Admin. approval of minor changes made to the EPC approved Site Plan to avoid existing utility lines that were not located correctly on the site survey (relocating dumpster enclosure); and to address constructability and durability concerns (minor adjustments to ext. facades).

EPC #20018-001760 / SI-2018-00223; City Council Hearing File # AC-19-2; SI-2019-00308

March 12, 2021

The purpose of this letter is to provide justification for the minor changes that have been made to the Environmental Planning Commission (EPC) approved Site Plan for the Singing Arrow Community Center located at 13200 Wenonah Avenue SE, in the Canada Village – Second Unit Subdivision in response to issues that have arisen during the construction of the project. The relevant project numbers for this project are: EPC Project #20018-001760/SI-2018-00223, City Council Public Hearing File #AC-19-2; and SI-2019-00308.

TITLE: **OVERALL SITE PLAN**

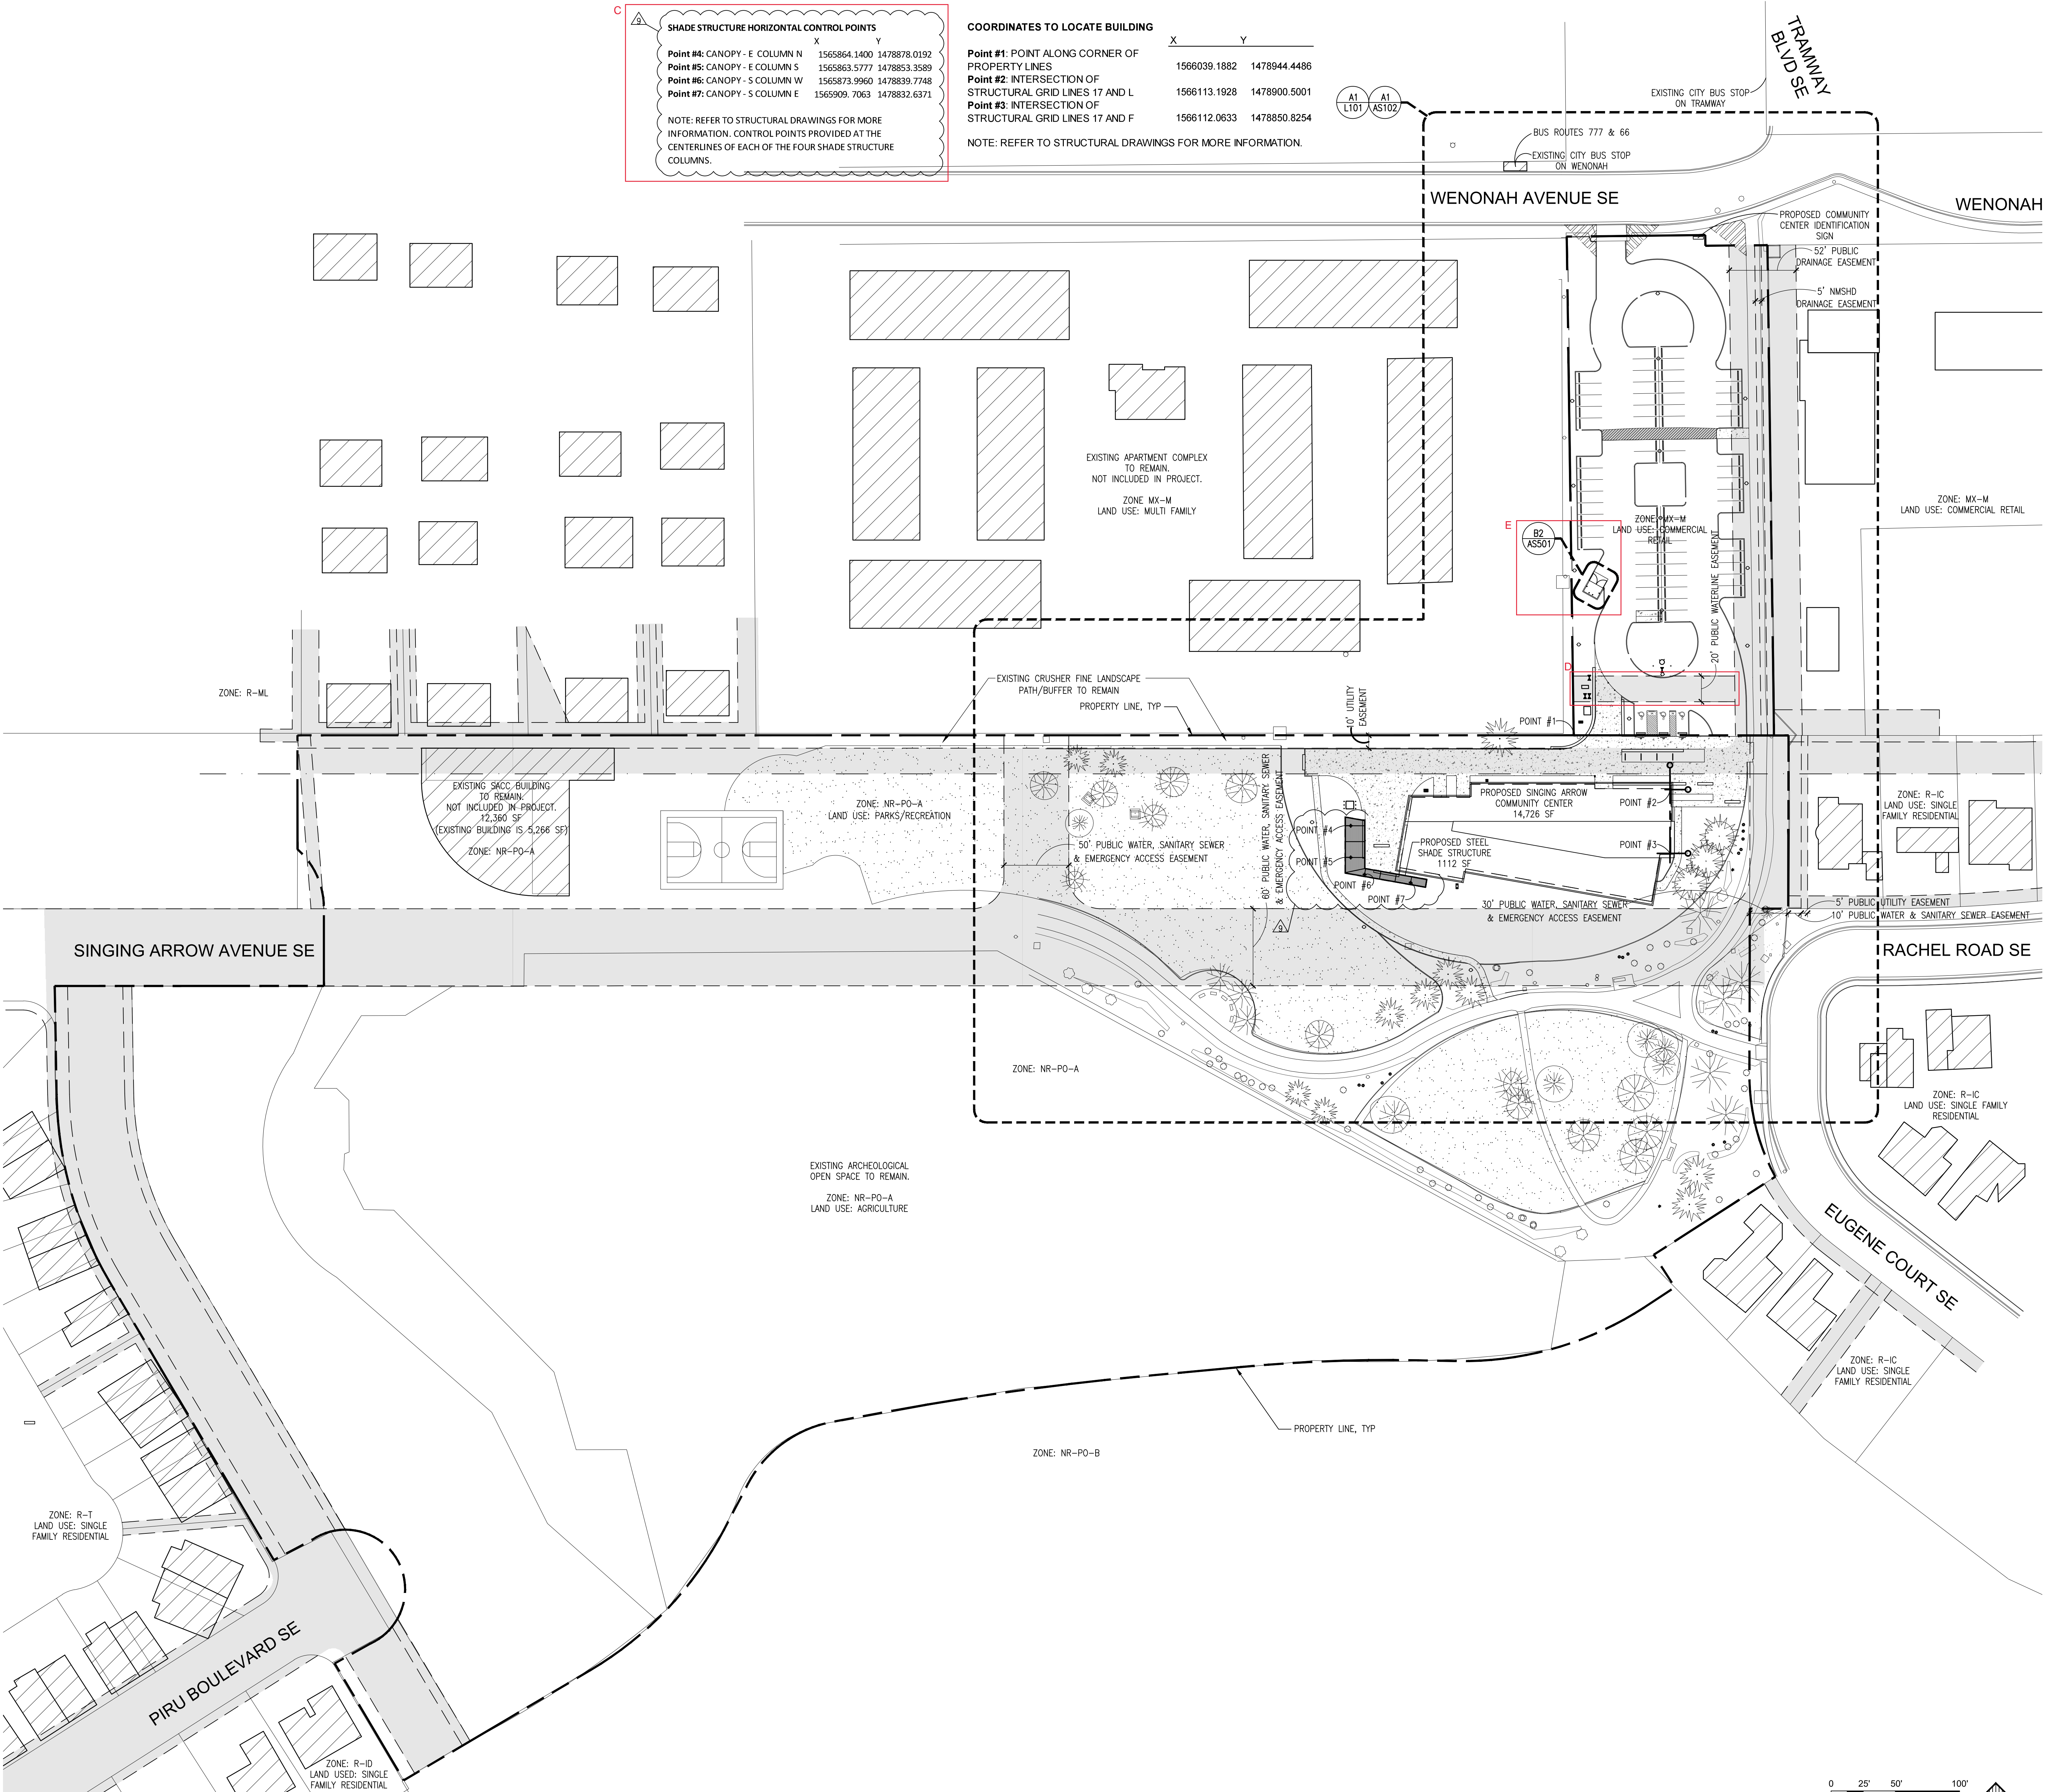
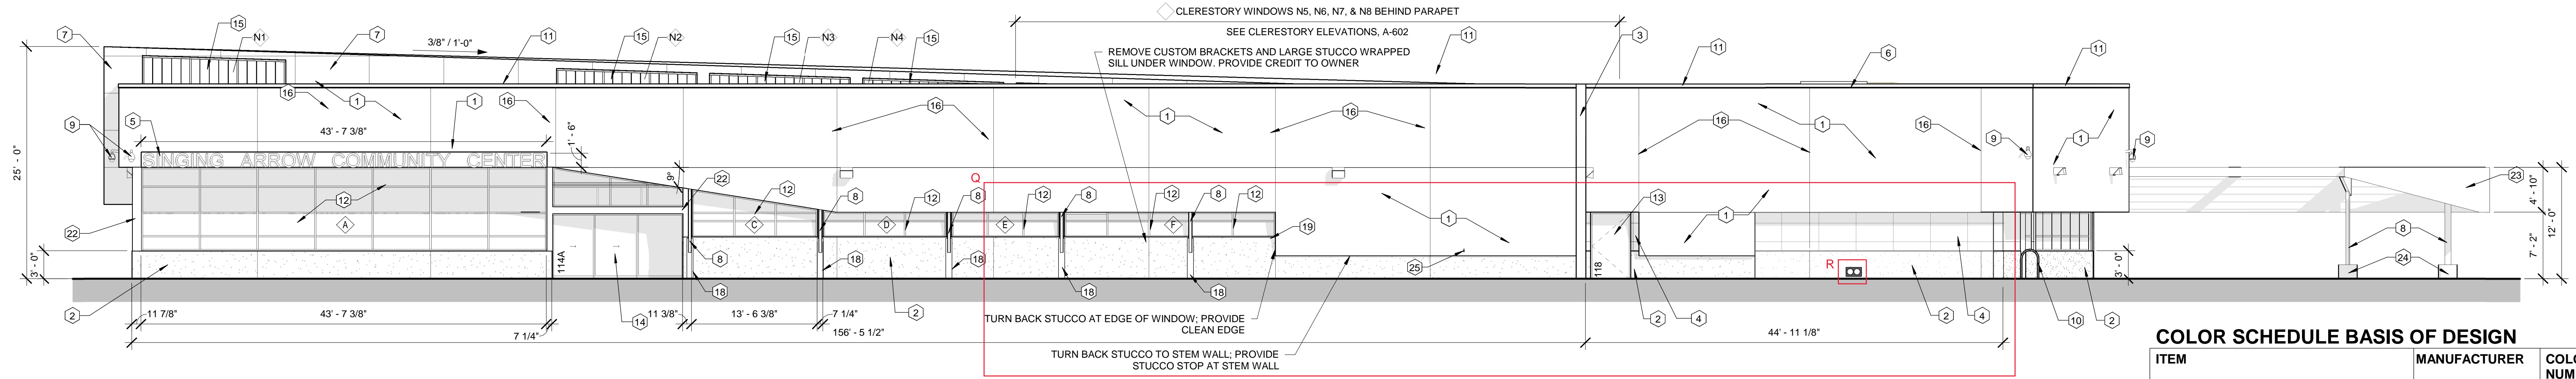
- C. We added a “Shade Structure Horizontal Control Points” chart to AS101 to provide additional information to the contractor, so they can accurately lay out the columns and footings for the shade structure. This does not change any information previously approved by the EPC and City Council, rather it draws out the information in a different format. Refer to Overall Site Plan drawing for notations of Points 4 through 7 as related to the property line and building.
- D. A 20’-0” public waterline easement was added per requirements from the ABCWUA.

- E. The dumpster enclosure was moved from the east edge of the parking lot to the west edge of the parking lot to avoid existing utility lines uncovered at the east edge of the site. An existing water line was shown on the survey approximately 15'-0" away from its actual location in the field. (MCR #020)

D1 NORTH ELEVATION
A-201

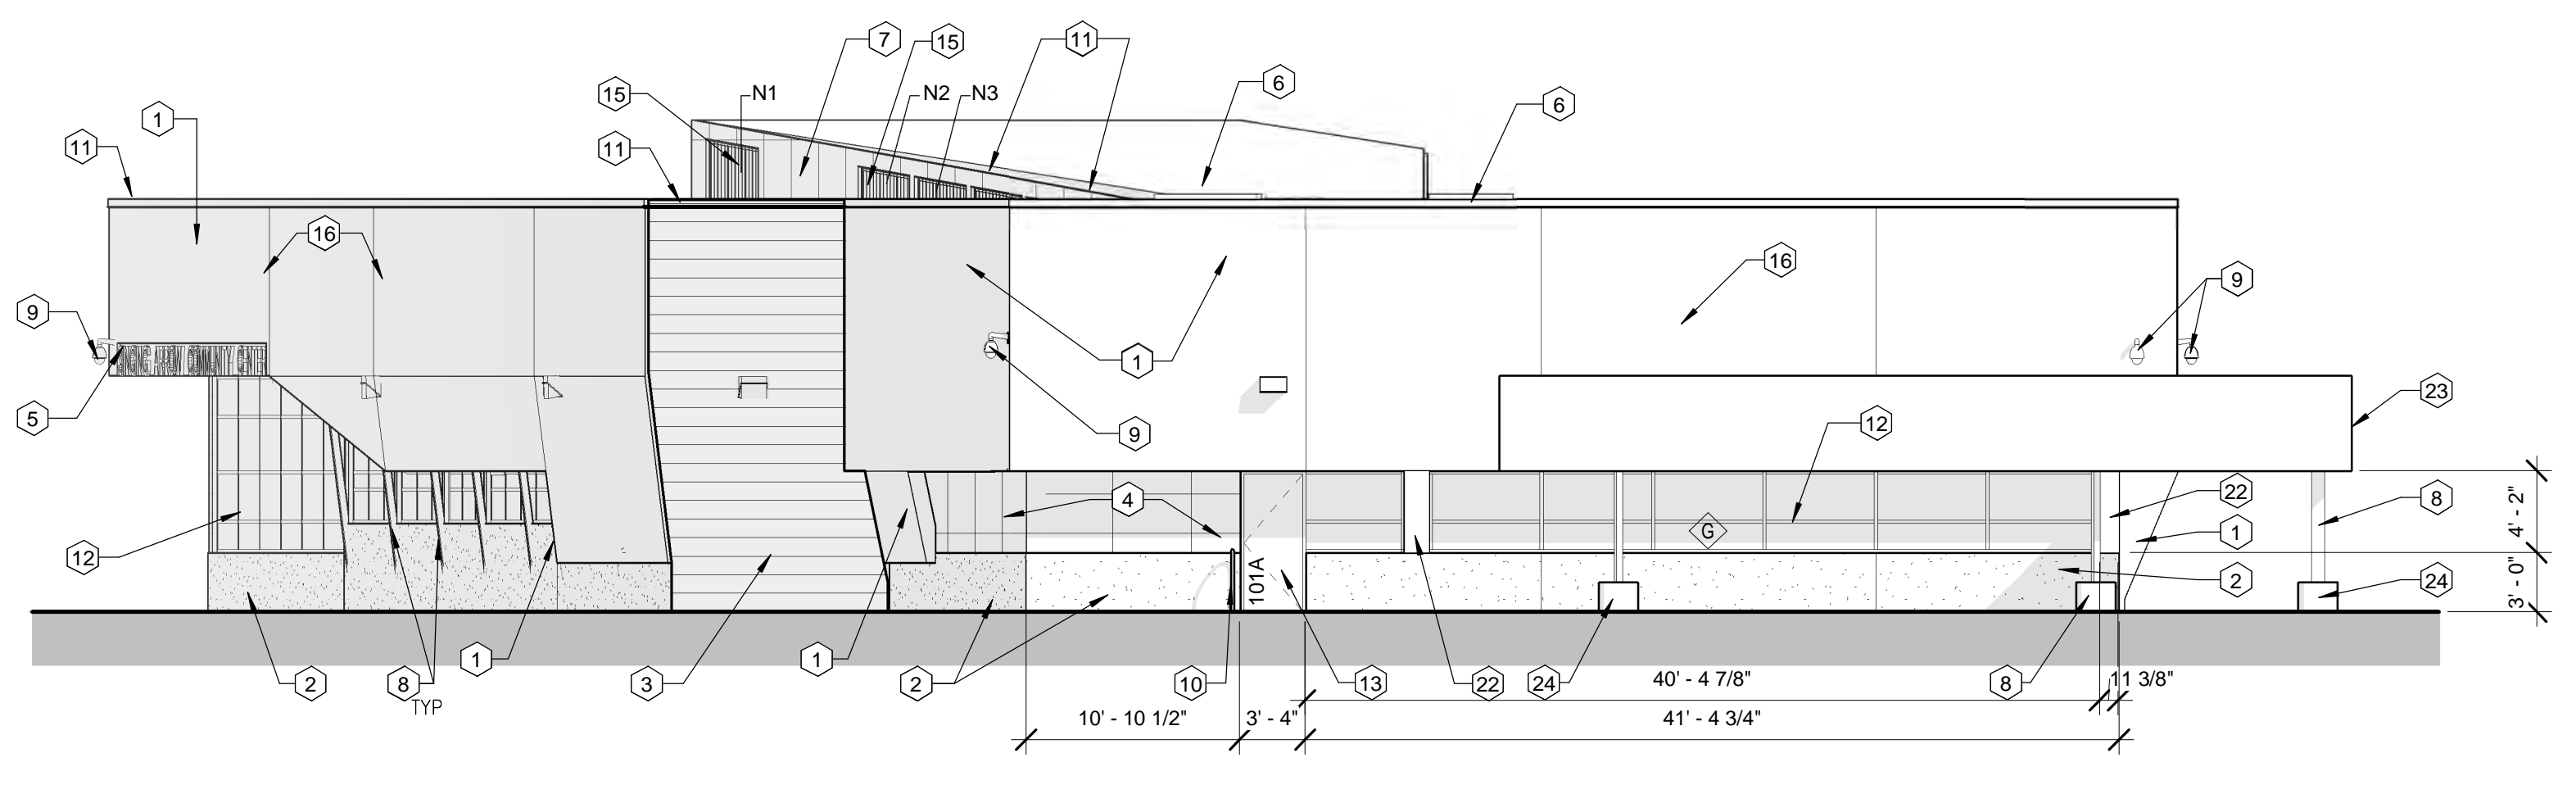
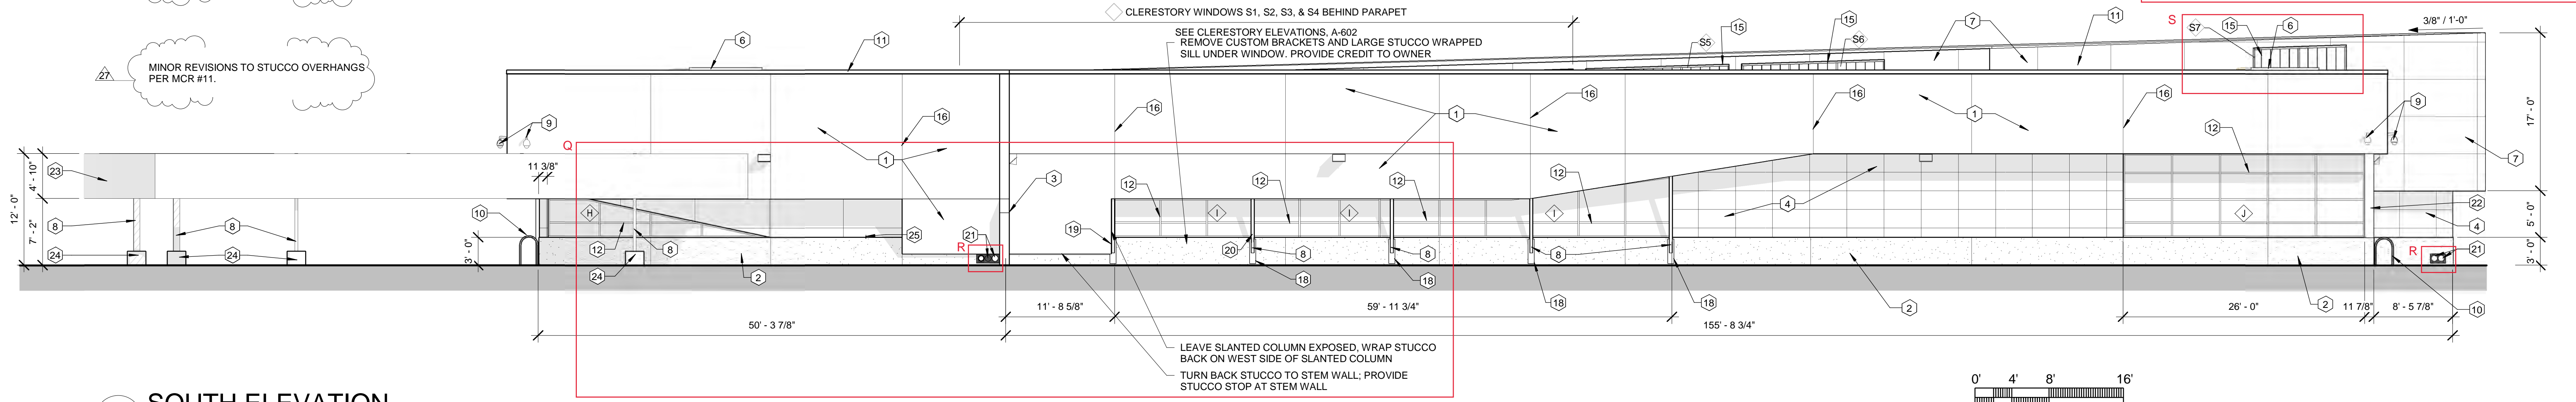
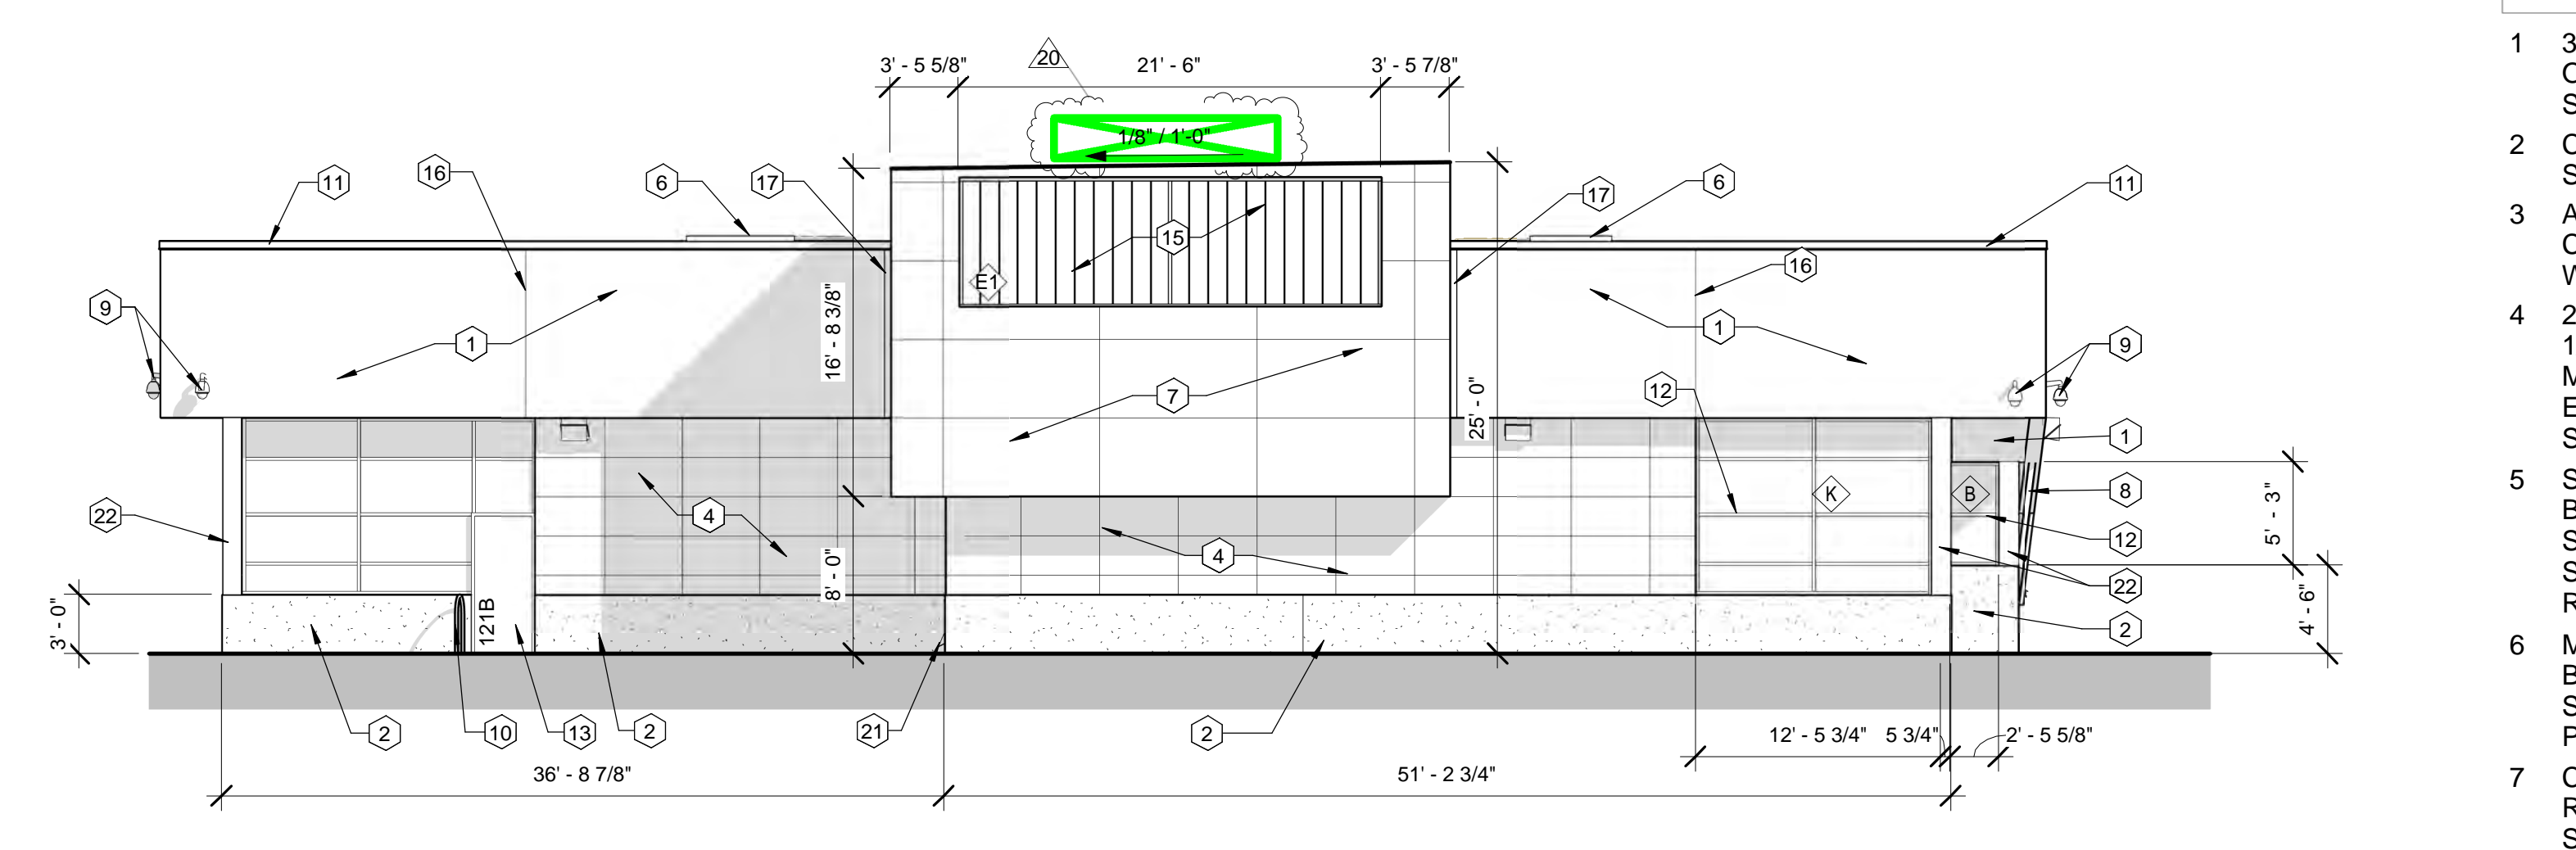
- Q. At the north and south facades of the building, the size and shape of the stucco portions of the wall were modified slightly to provide for cleaner details at the base and overhangs of the wall, and to ensure improved durability at the areas under the windows. In response, the areas that are finished in exterior tile expanded slightly. (MCR #011).

- a. The total opaque square footage remains unchanged. See façade calculations chart on A-201 for updated calculations.
  - b. The total square footage of exterior tile changed from 1,098 sf to 1,160 sf (a 5% change).

- c. The total square footage of stucco changed from 9,559.3 sf to 9,157 sf (a 4% change).
- R. Corten steel cover plates were added at all exterior roof drain/overflow roof drain penetrations to provide improved durability and weather tightness in those areas (MCR #011). An additional set of roof drain/overflow roof drain penetrations was added on the north side of the building to allow for improved sloping of the roof drain piping inside the building (ASI #15).

- a. The total square footage of the added corten steel panels is 4 sf.
- S. Clerestory window S7 on south wall of building to be 10'-0" wide in lieu of 15'-1" wide clerestory unit shown on approved Site Plan exterior elevations to avoid structural column running through opening. (ASI #21). Only 1 clerestory window out of a total of 16 clerestory windows was modified. Percentage of change of total clerestory windows is less than 10%.
